Please refer to the comments provided in the Transportation Memorandum included with the Timbers at Black Forest (P269) submittal package and update the memo accordingly. Be sure to include any information or analyses that those comments specifically identify as required at the final plat stage.

TRANSPORTATION MEMORANDUM

**Timbers at Black Forest
El Paso County, Colorado**

PCD File No. SF2616

Figure 1
SITE LOCATION

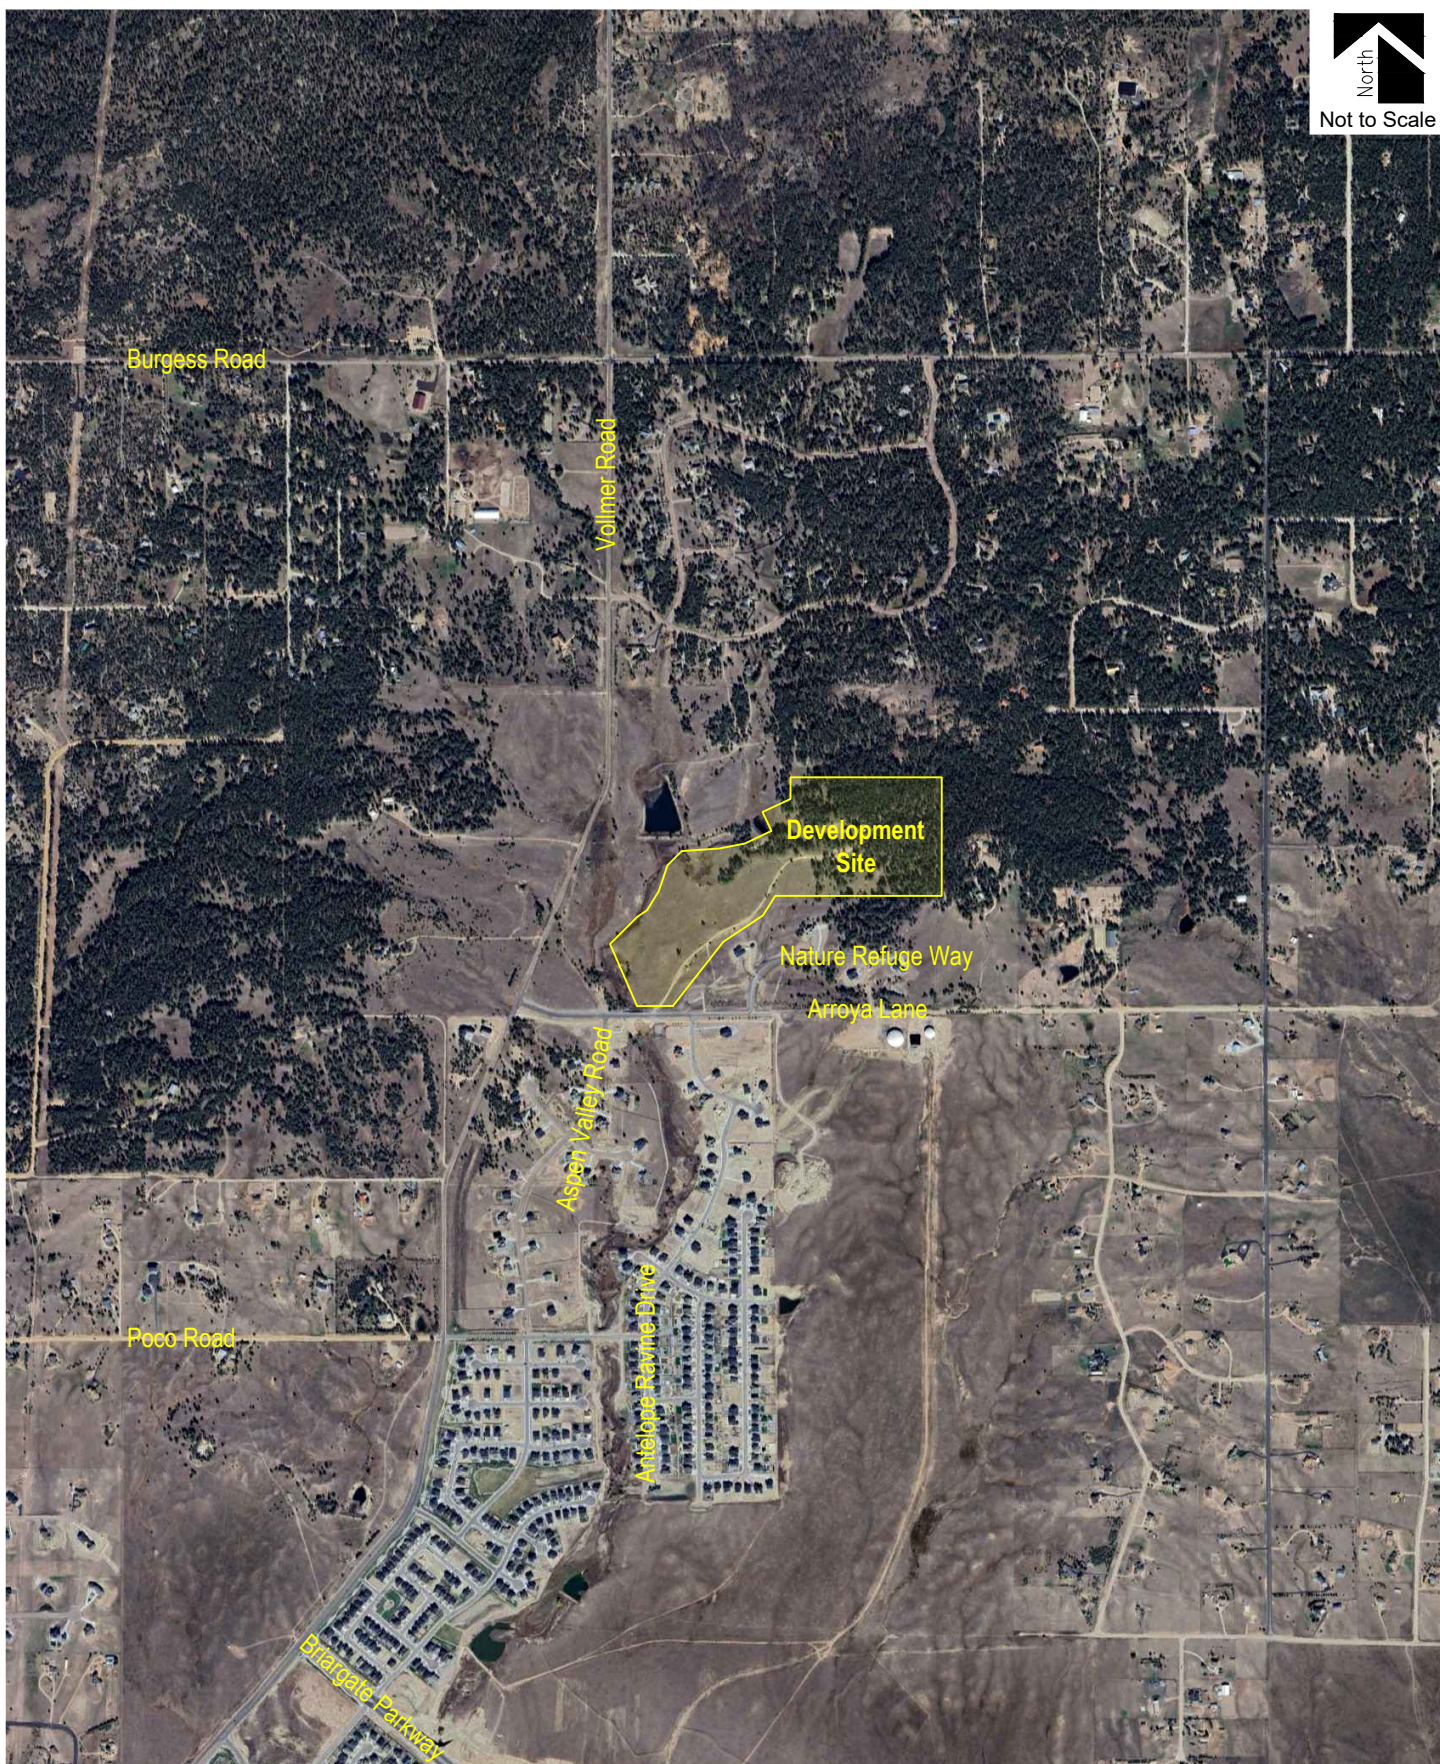
As noted in Rezone TIS, please include an analysis of the Briargate intersection also.

TOTAL TRAFFIC - YEAR 2028

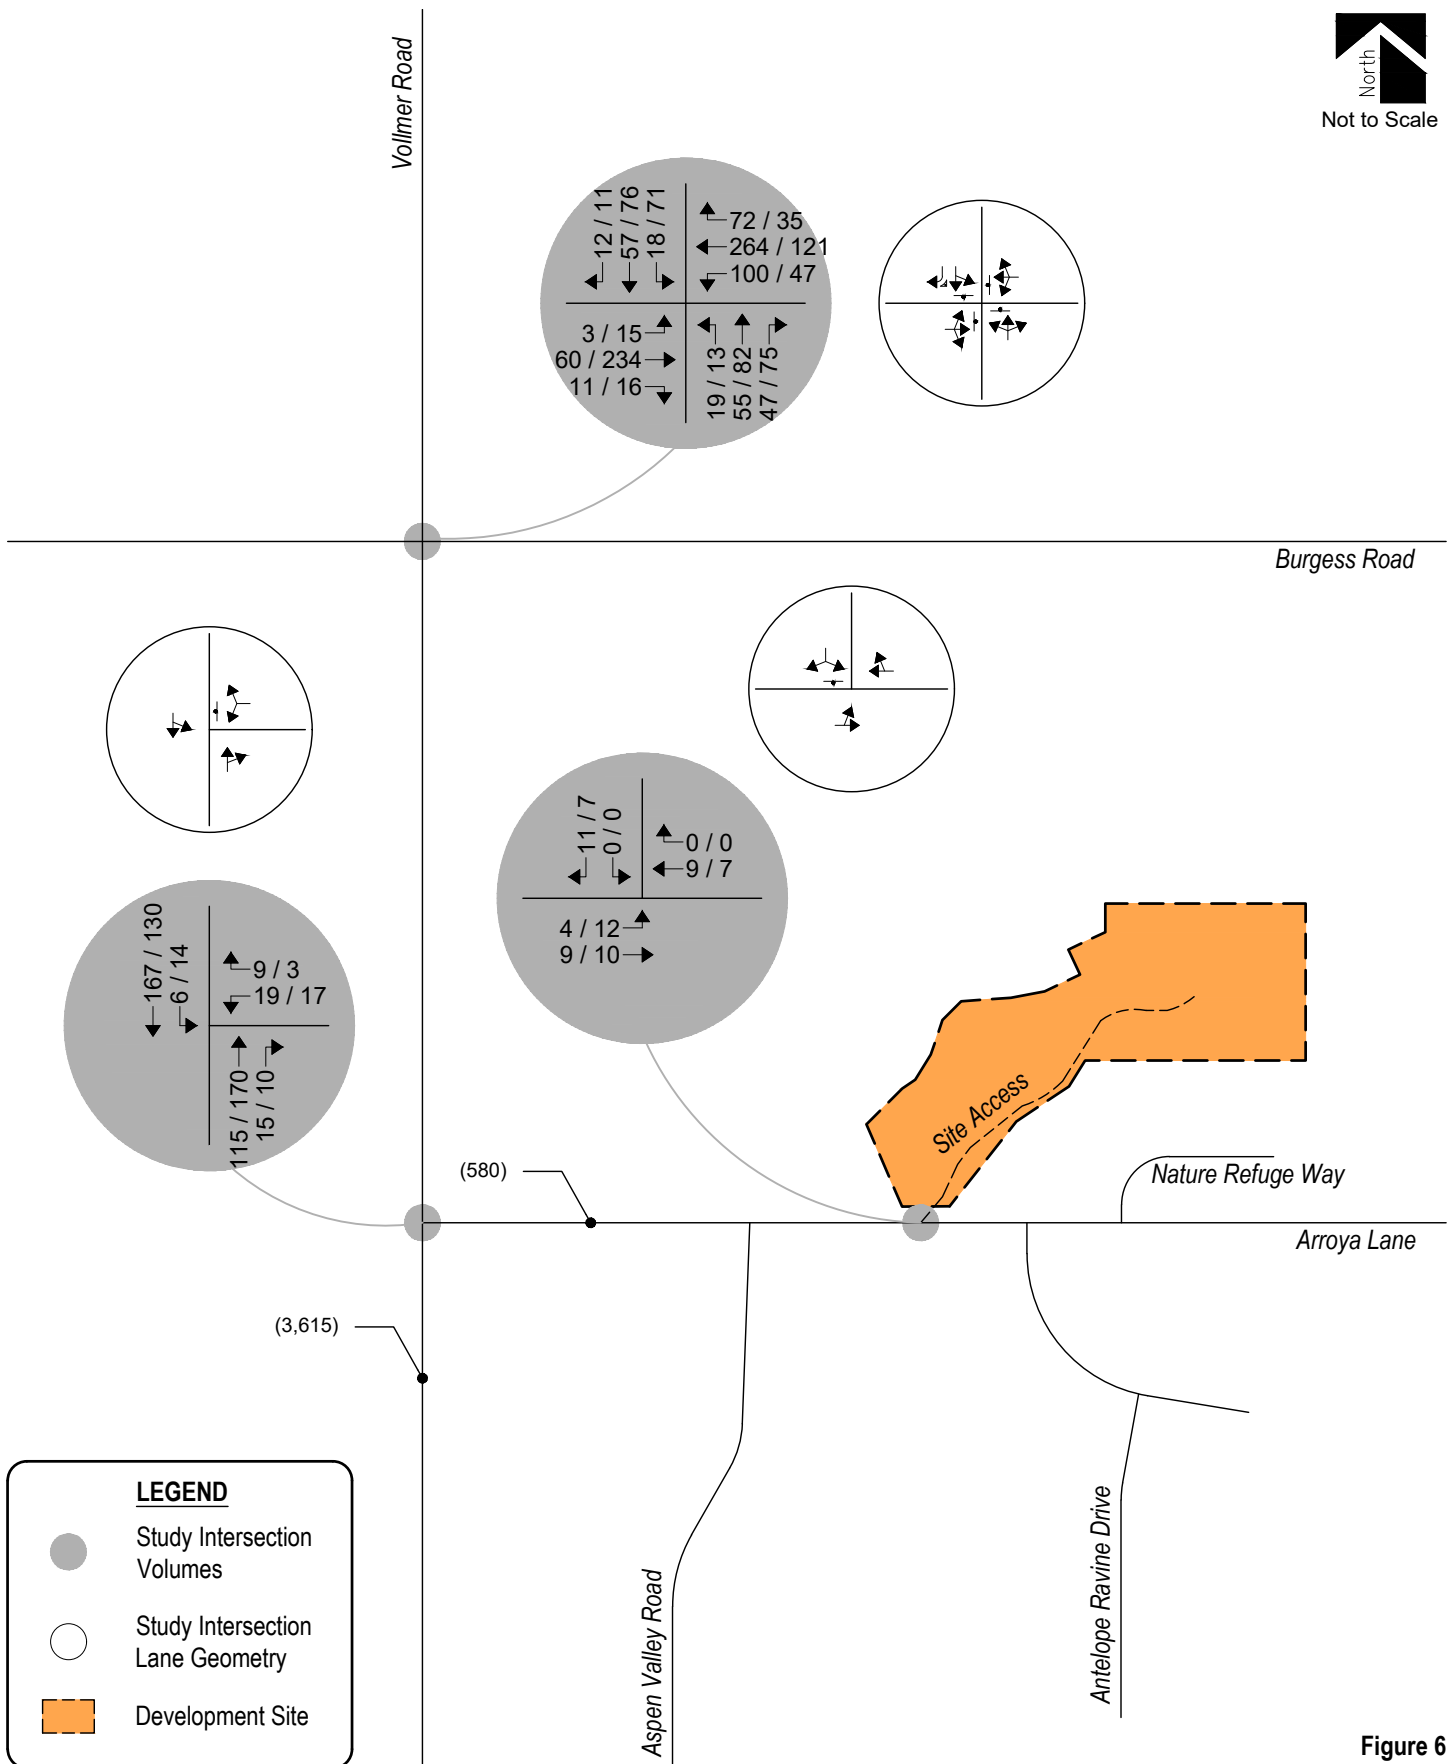
Detail is very hard to read
